KIRKLEES METROPOLITAN COUNCIL INVESTMENT & REGENERATION SERVICE

DELEGATED DECISION TO DETERMINE PLANNING APPLICATIONS

Reference No:	2025/62/91049/W
Site Address:	6, Highcroft, Upperthong, Holmfirth, HD9 3HE
Description:	Demolition of existing conservatory and erection of single storey rear extensions, garage conversion, creation of car port and associated external alterations
Recommending Officer:	Joshua Merriman

HOUSEHOLDER DELEGATED REPORT

Drawing Number
25_B01 106

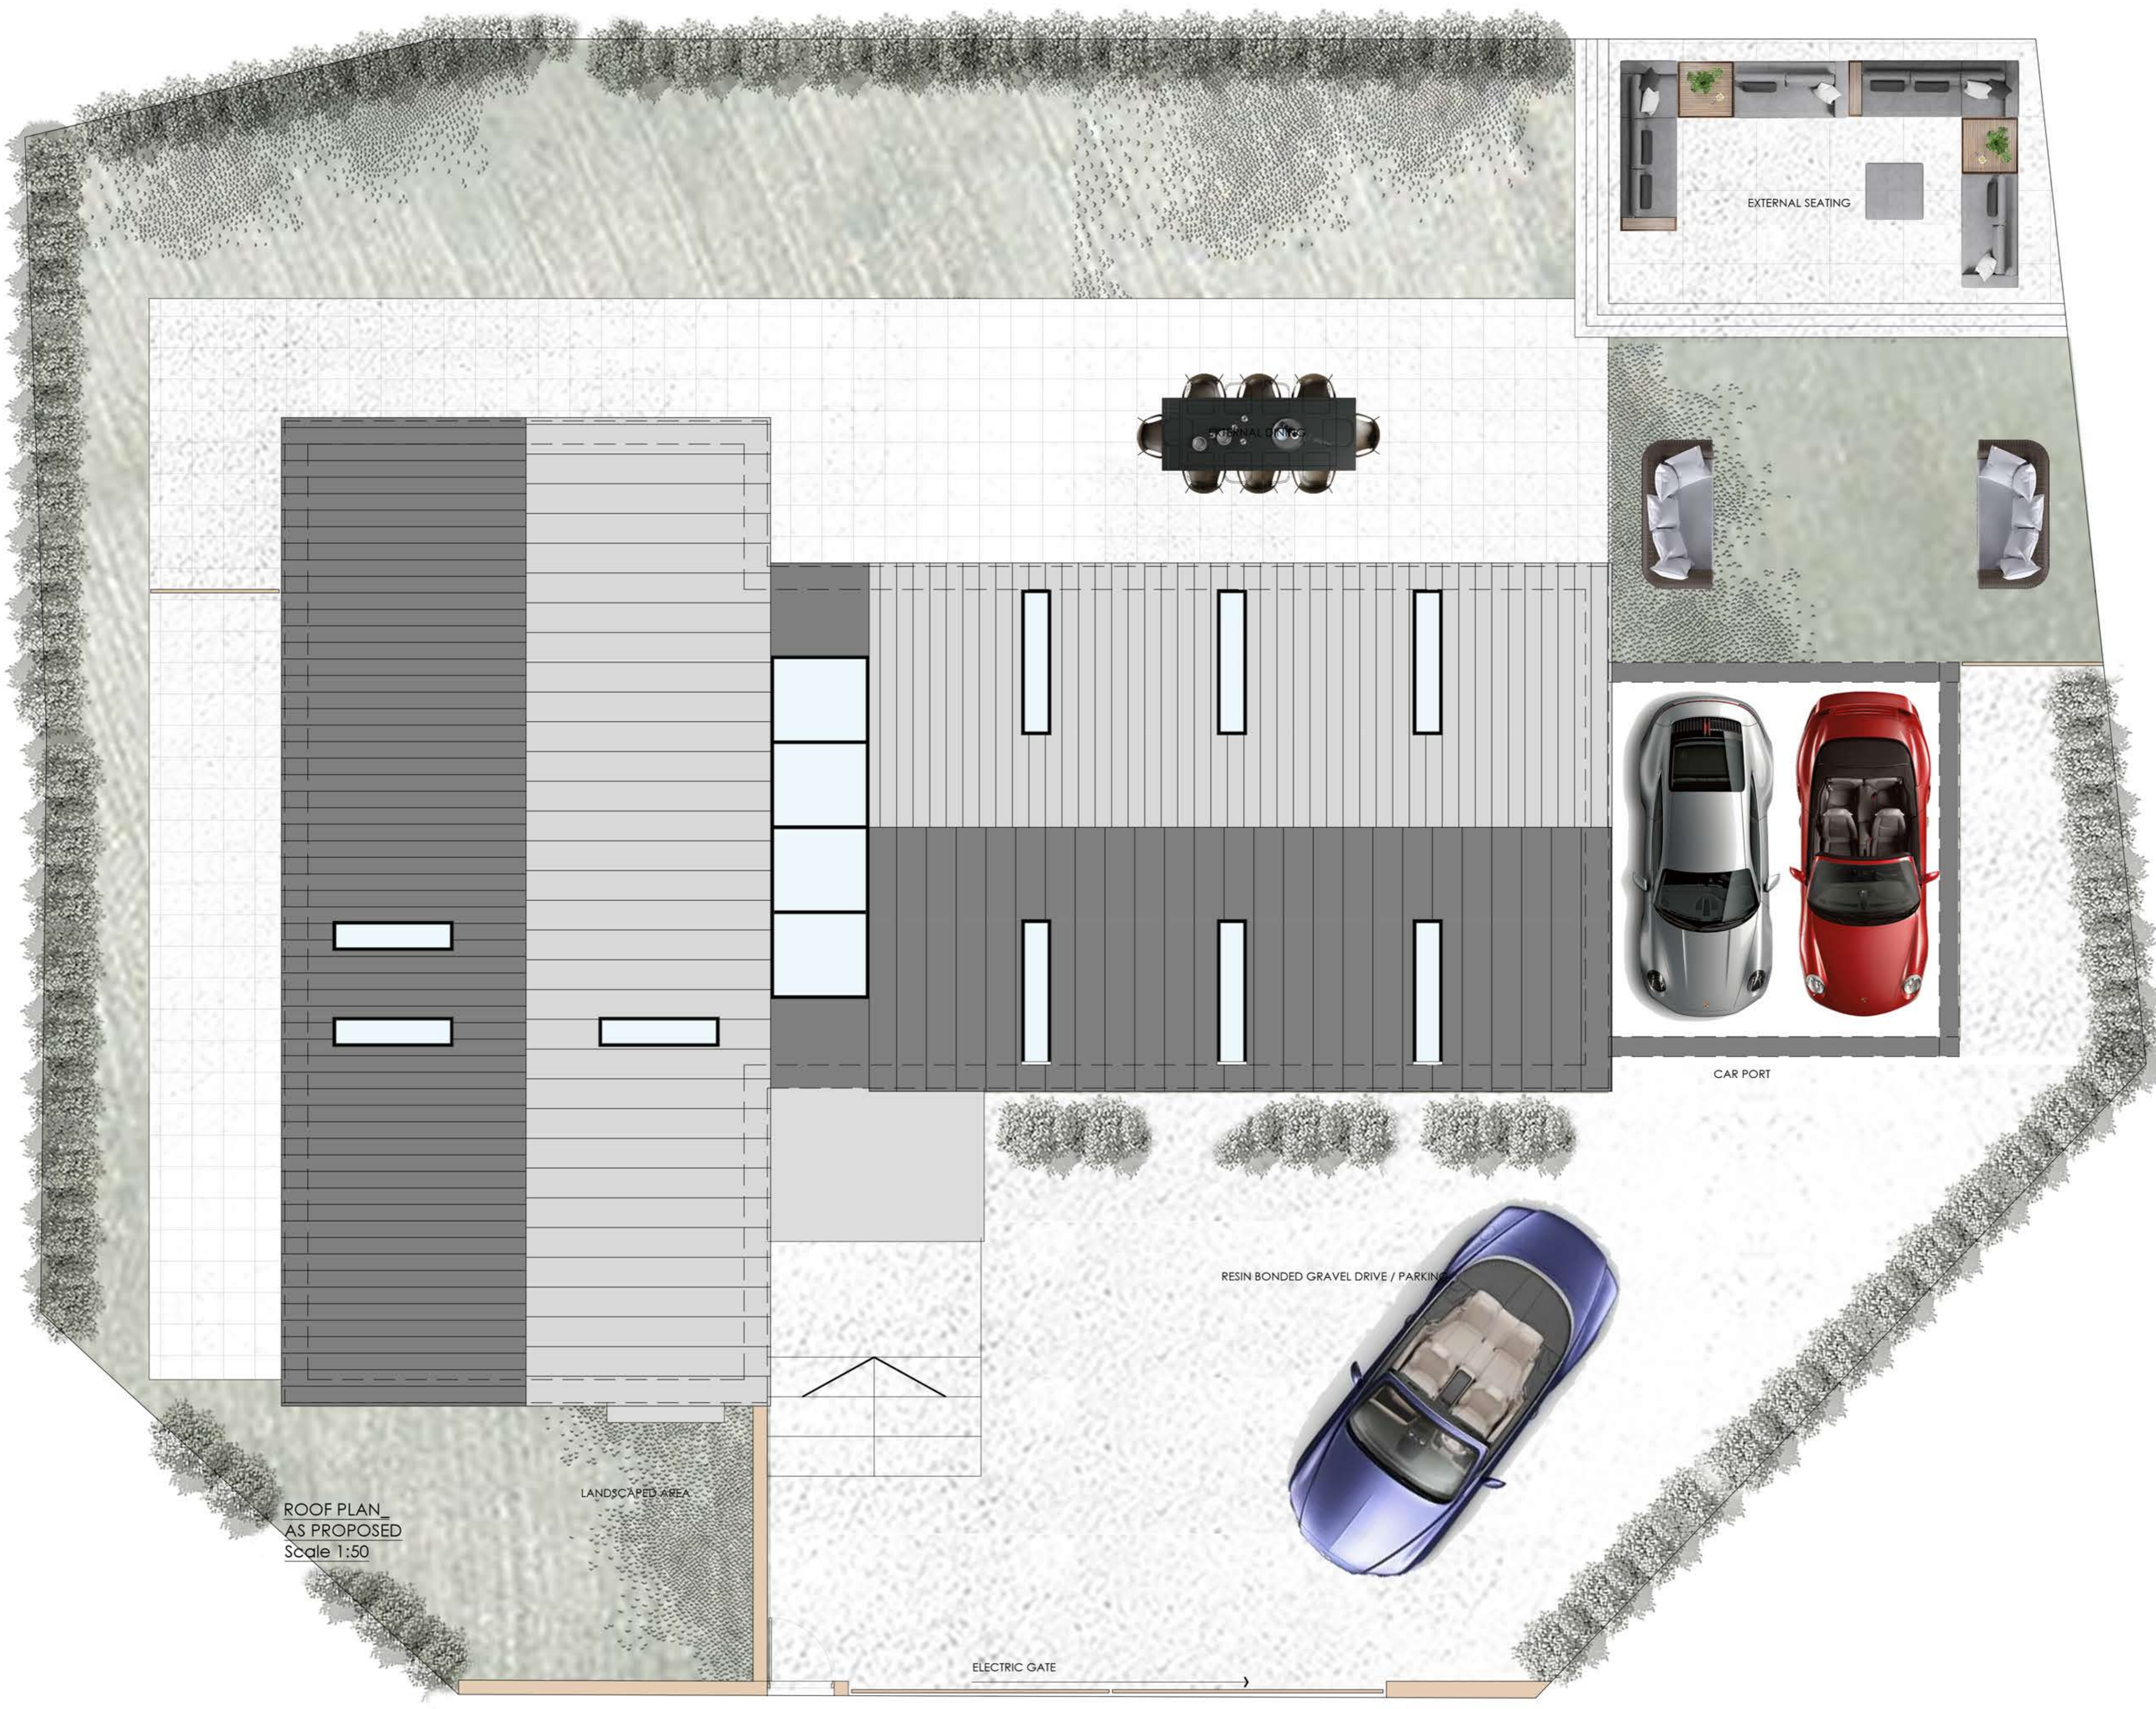
It is noted a raised patio is proposed to the rear, on the basis this is no greater than 1m in height above ground level it is considered the visual impact of this element of the proposal would not be significant and a condition to ensure this is the case is recommended.

The proposal does demonstrate a raised area to be used as a patio in the north eastern corner of the garden. This element would need planning permission were it to be greater than 0.3m in height, given the siting of this element of the proposal and on the basis it is constructed such that it is not greater than 1m in height, given its siting and fact the existing building would largely screen its view from neighbouring occupiers, it is considered this element would not lead to a significant impact in terms of overlooking of neighbouring occupiers.

4. Any new surfacing to the area annotated 'resin bonded gravel drive / parking' upon submitted drawing ref 25_801106 shall be surfaced and drained in accordance with the Communities and Local Government; and Environment Agencies 'Guidance on the permeable surfacing of front gardens (parking areas)' published 13th May 2009 (ISBN 9781409804864) as amended or superseded; and thereafter retained throughout the lifetime of the development.

5. The area annotated 'external seating' upon submitted drawing 25_801 106 shall not exceed 1m in height above the existing ground level.

Drawing Number
 25_801_105

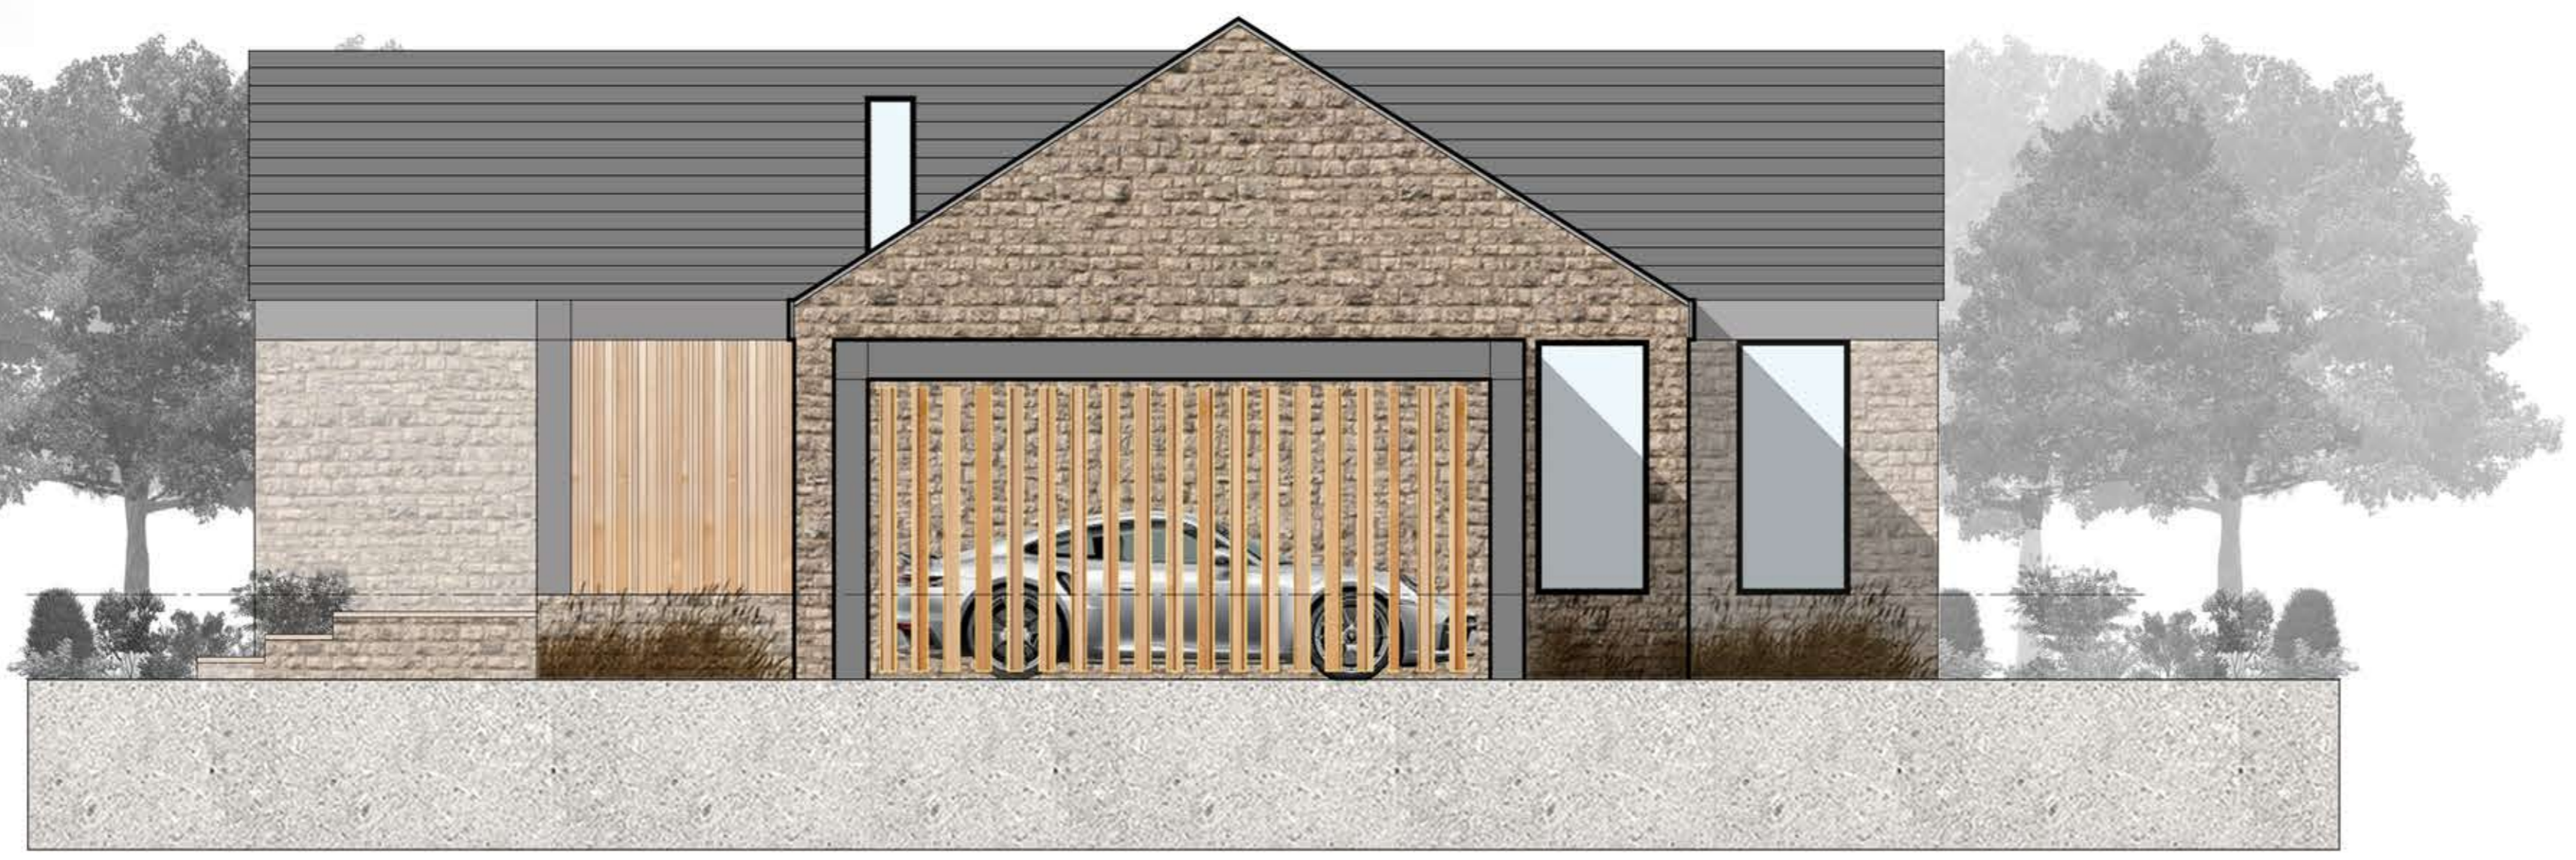
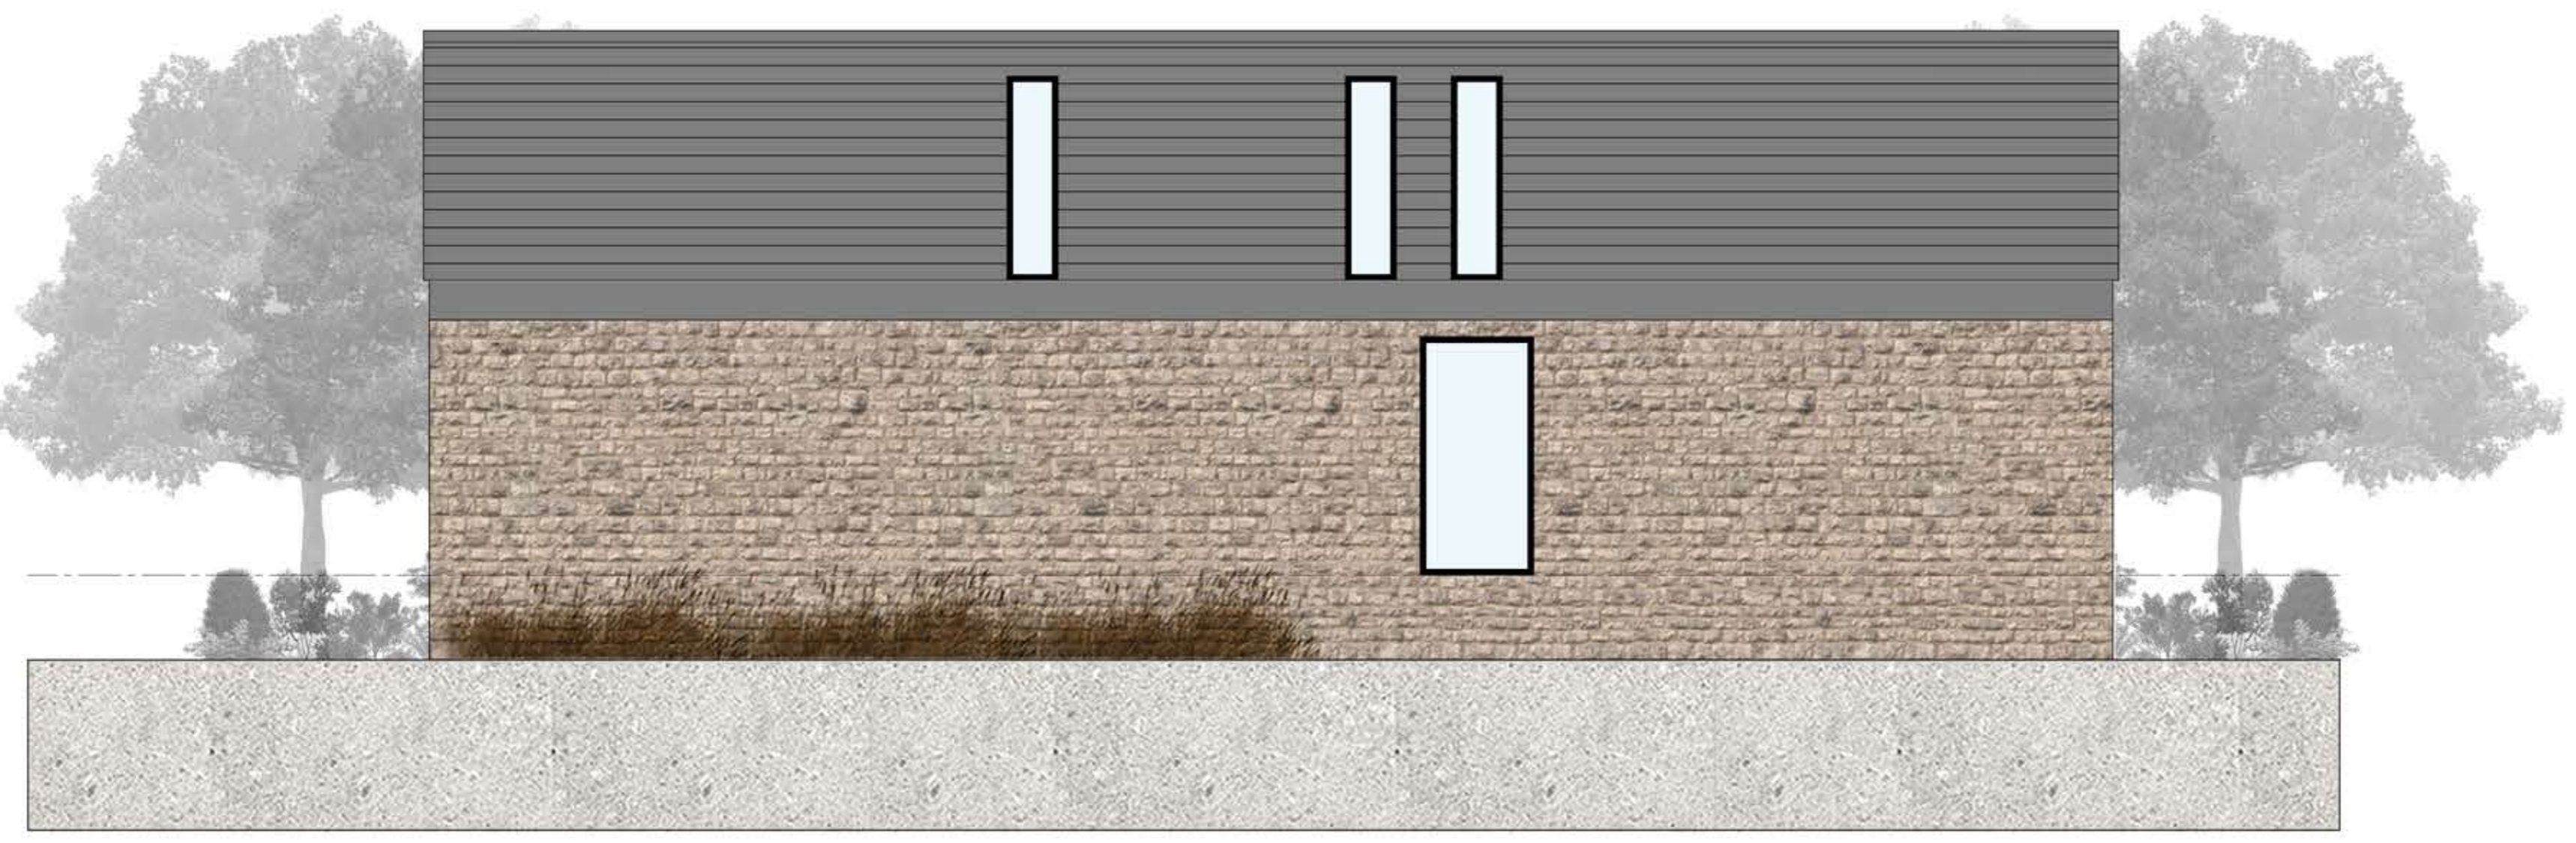
The proposed single storey rear extension will project 2.19m from the rear elevation of the existing dwelling, with a maximum height of 5.58m, eaves height of 3.35m, and a width of 7.32m.

The proposed car port to the side of the dwelling will project 5.33m from the side elevation of the original house, with a maximum height of 3.22m, eaves height of 2.89m, and a depth of 6.08m.

not exceed 4 metres in height		The maximum height of the rear extension is 5.58m, exceeding 4m, however, as it is located to the rear and

not considered to have any adverse impact on neighbouring dwelling it can be considered acceptable in this case.
not project out more than 3 metres from the rear wall of the original house for semidetached and terraces houses or by 4 metres for detached properties	The rear extension will project 2.19m from the rear elevation of the host dwelling, not exceeding the 4m allocated for detached dwellings.	
where they exceed 3m in length the eaves height should generally not exceed 2.5 meters	The extension does not exceed 3m in length.	
retain a gap of at least 1 metre from a property boundary, such as a wall, fence or hedge	A gap of at least 1m is retained to all surrounding property boundaries.	
Side extensions	<u>Yes - COMPLY</u>	<u>No - JUSTIFY</u>
Ensure reasonable levels of natural light to the habitable rooms in neighbouring properties	Due to the side extension being used as a car port, it is not a solid extension, moreover, it is located far enough away from neighbouring properties to have no significant impact on the levels of natural light entering habitable rooms in neighbouring dwellings.

Facing materials and detailing	• KDP 9 of the SPD • Policy LP24 Design (d) (iii) of the KLP • Chapter 12 of the NPPF	The rear extension will be faced in stone and timber cladding, uPVC/aluminium windows will be used and zinc will be used for the car port. Timber cladding is also intended to be used to the building. Although not matching the existing building, these materials are	✓

3. The external stone walls and roofing materials to the pitched roofs used in the construction of the development hereby approved shall in all respects match those used in the construction of the existing building and be retained thereafter.
